Our Ref: M/103/11/
Your Ref:

Please ask for:
Mrs D Johnson
(01903) 737500 Ext 37762
16th November 2011

Single storey front extension to replace existing porch and single storey rear extension to replace existing conservatory.
44 Southdeean Close Middleton on Sea

Floor Plans and Elevations - as Existing

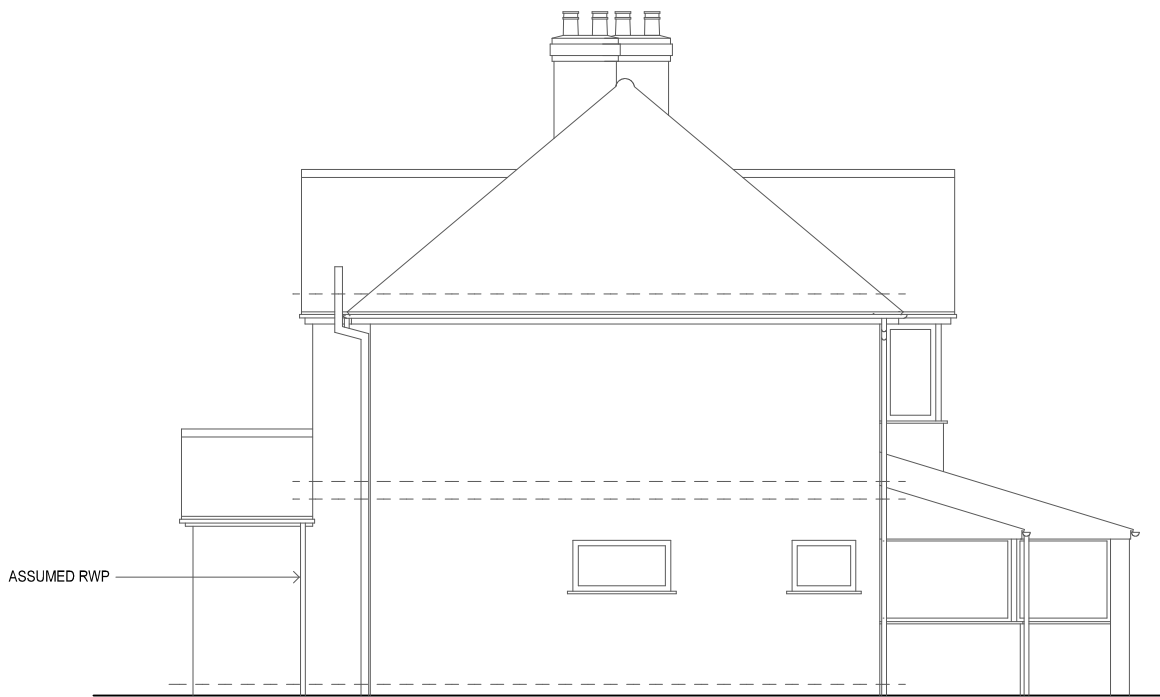
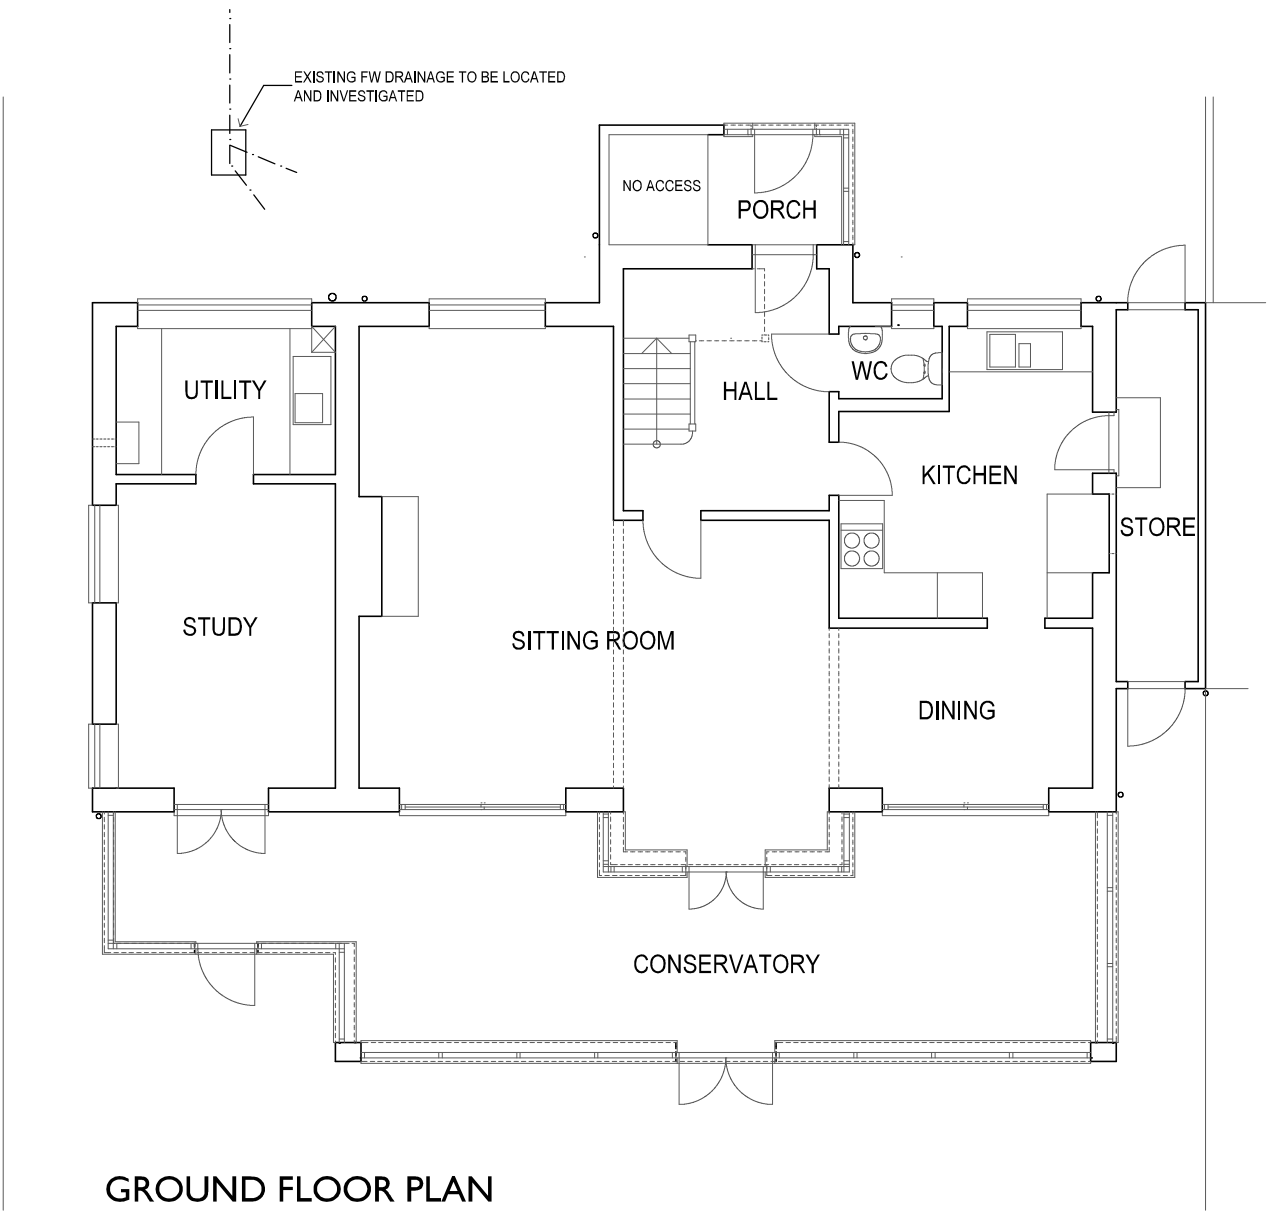
The existing East elevation at ground floor level and existing East ground floor plan do not accord. Please amend accordingly.

Floor Plans and Elevations - as Proposed

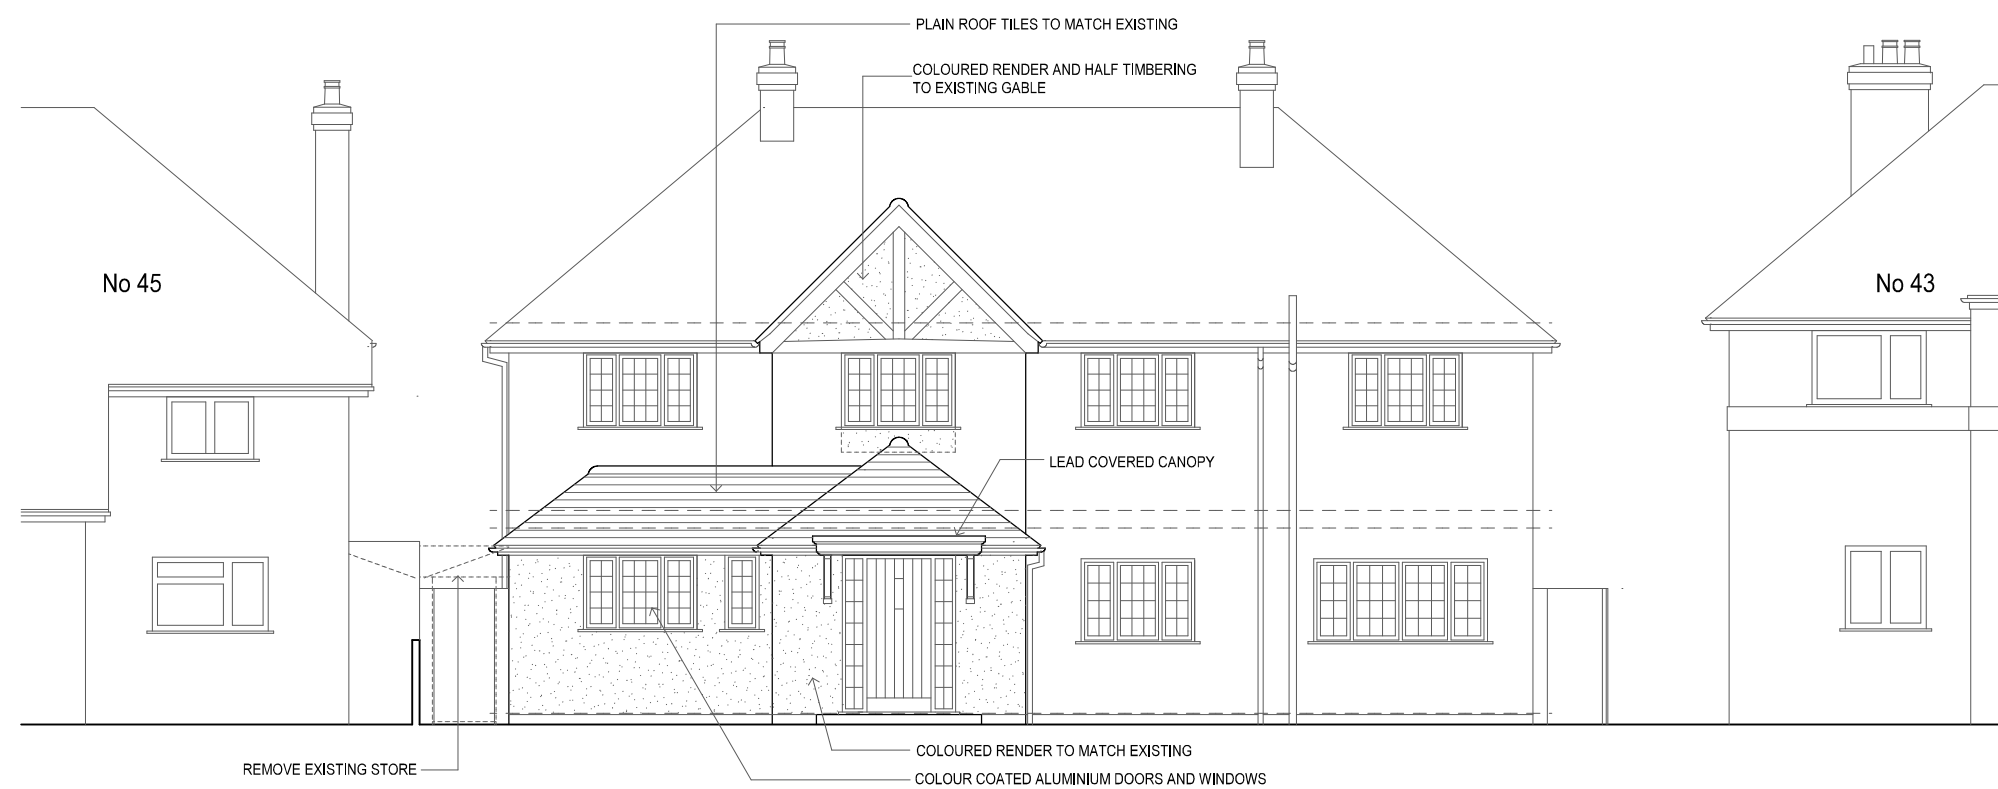
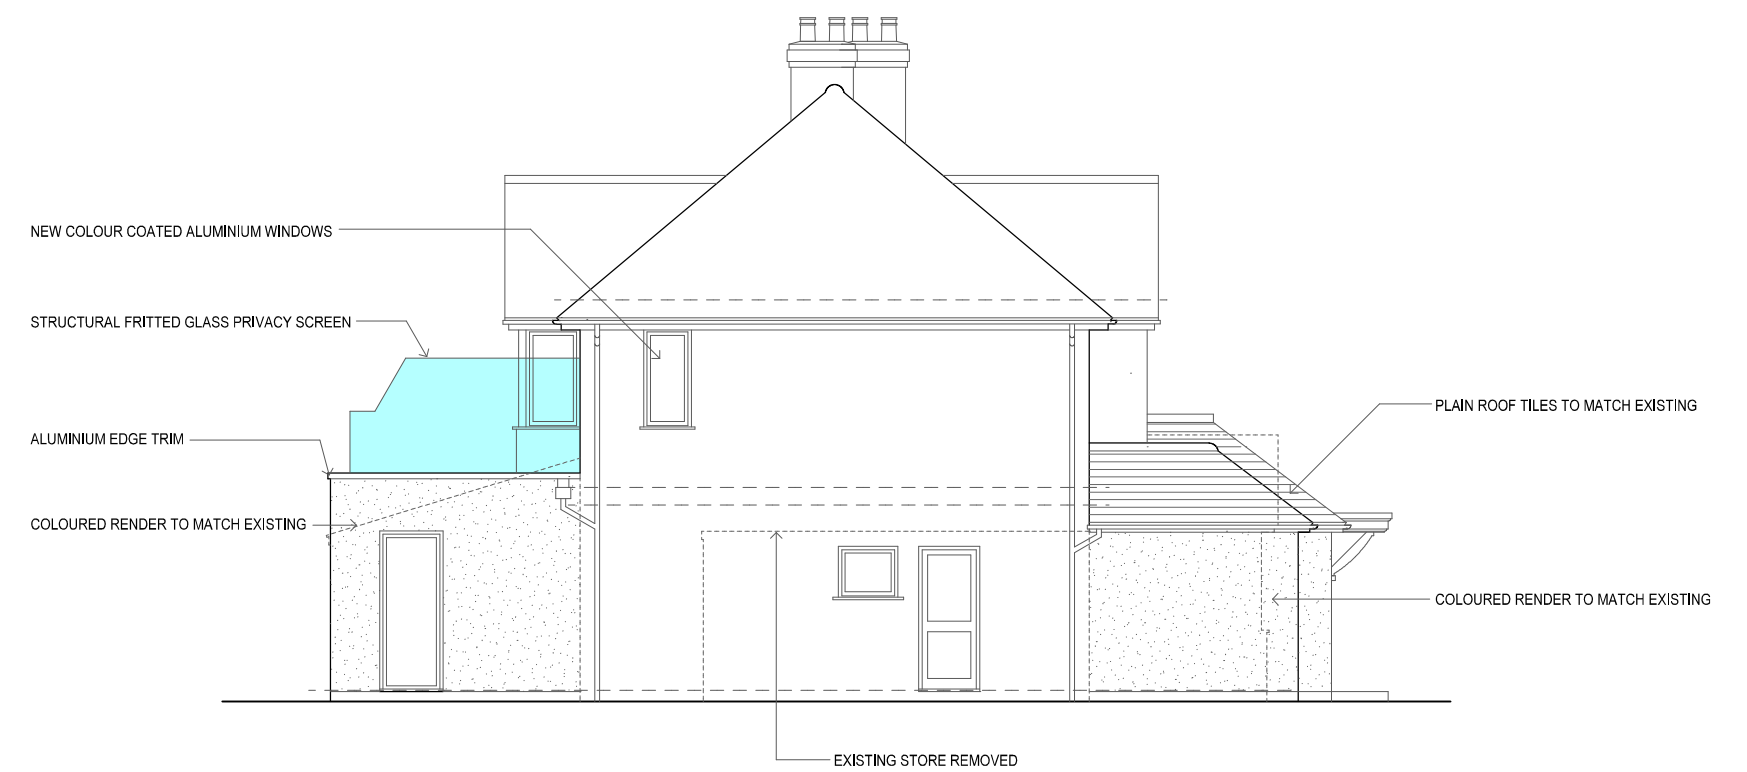
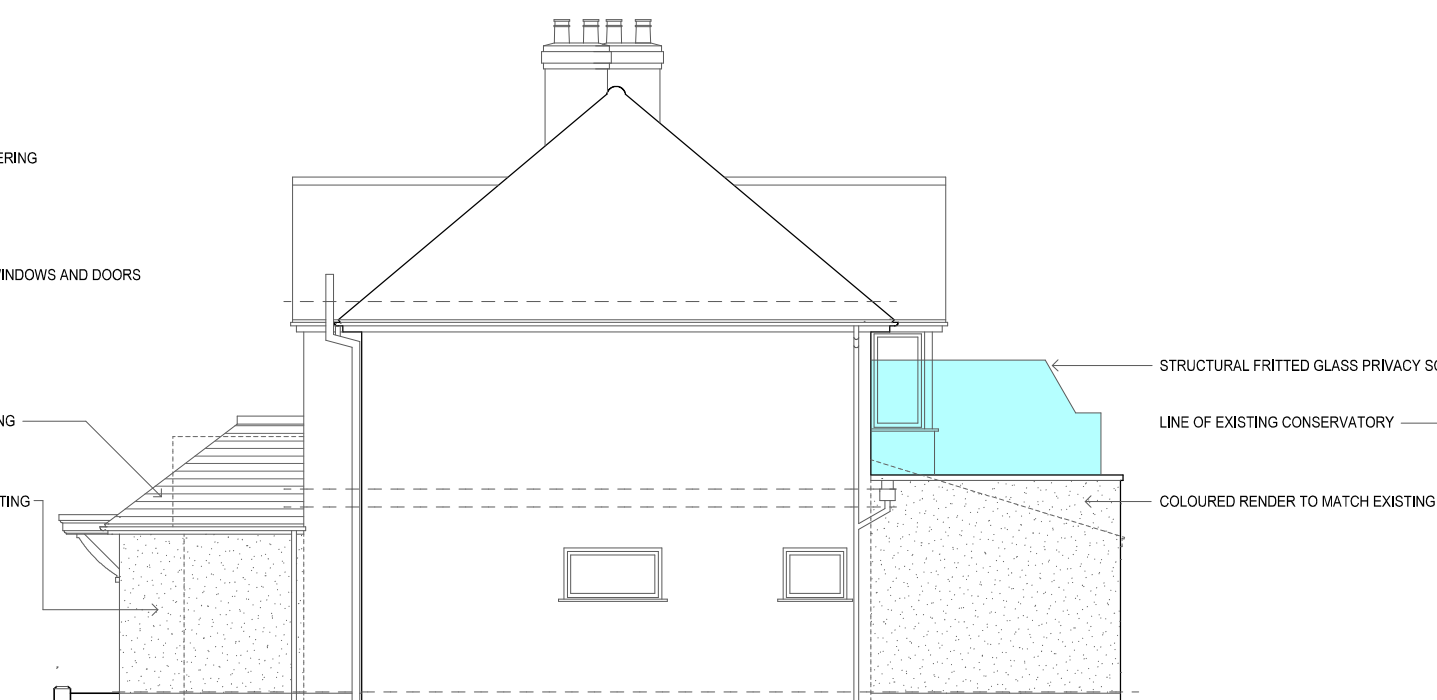
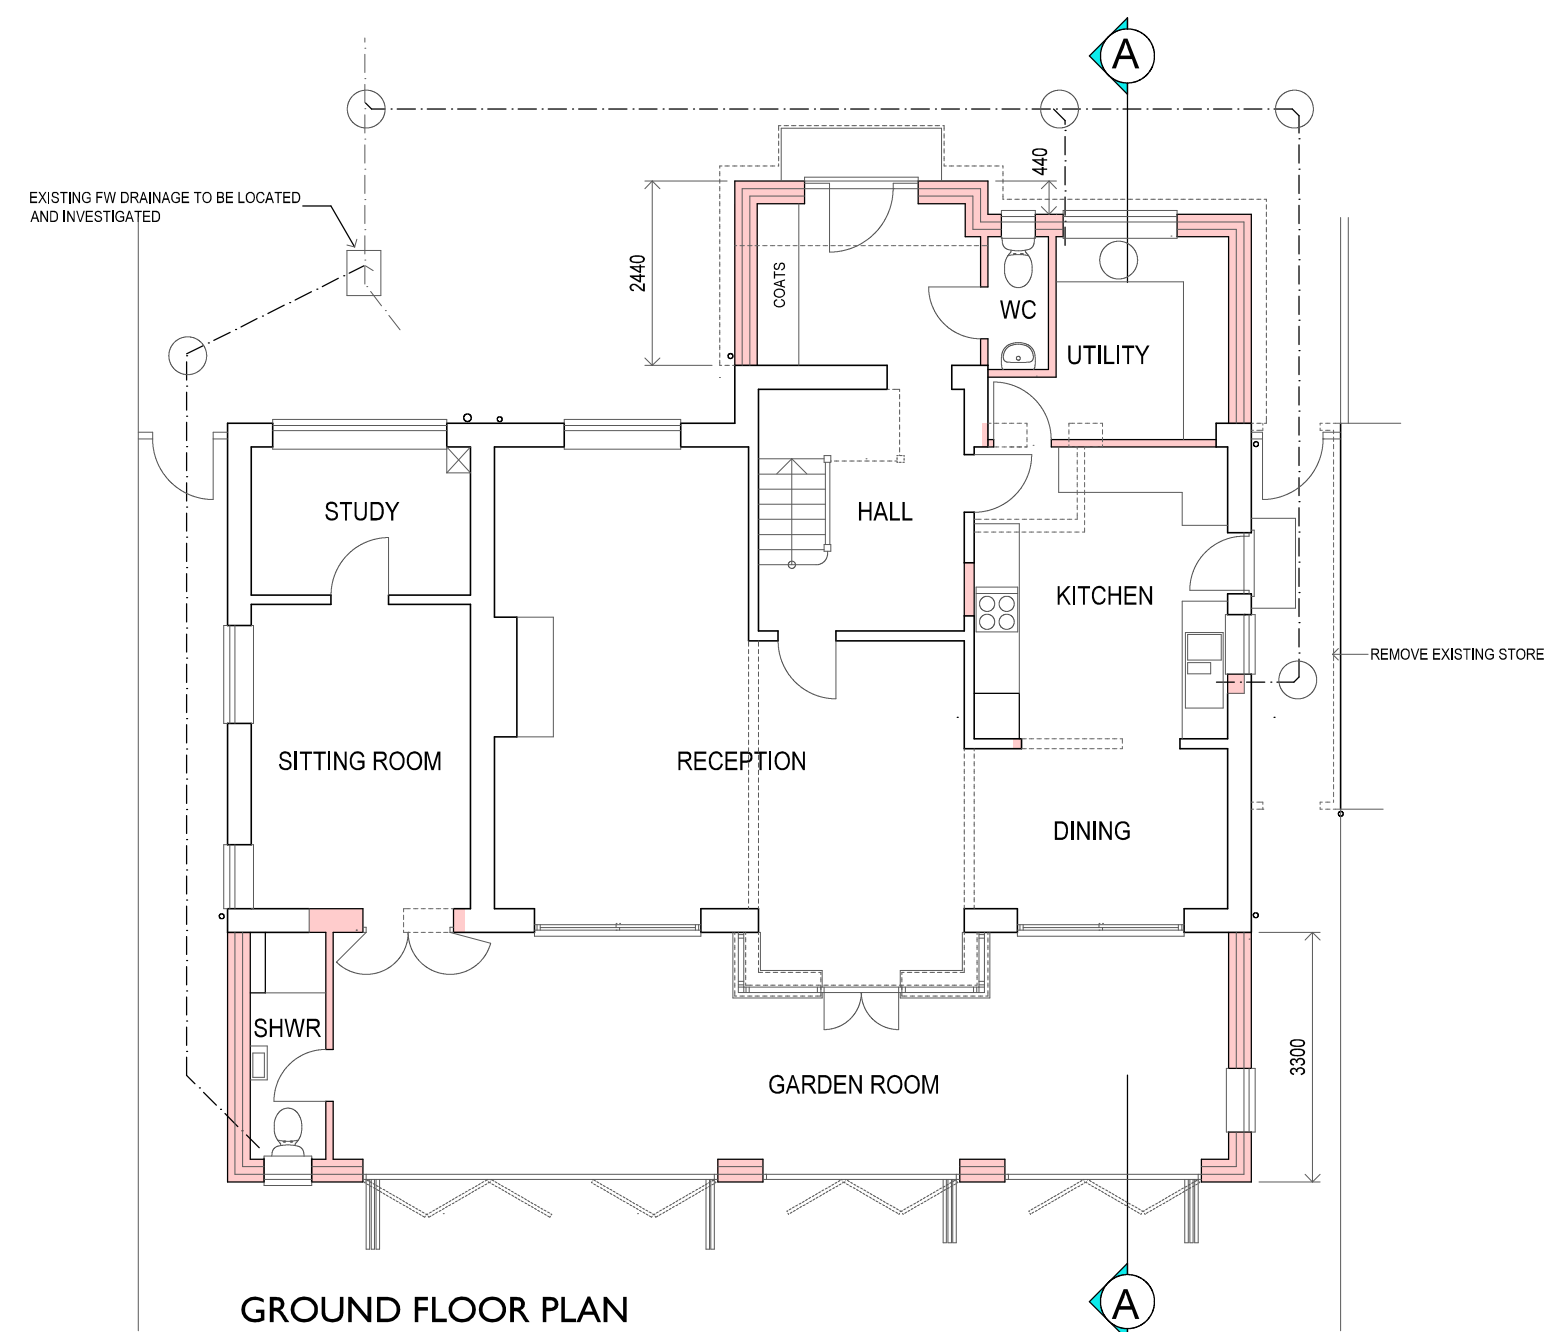
The proposed West Elevation at ground floor level and existing West ground floor plan do not accord. Please amend accordingly.
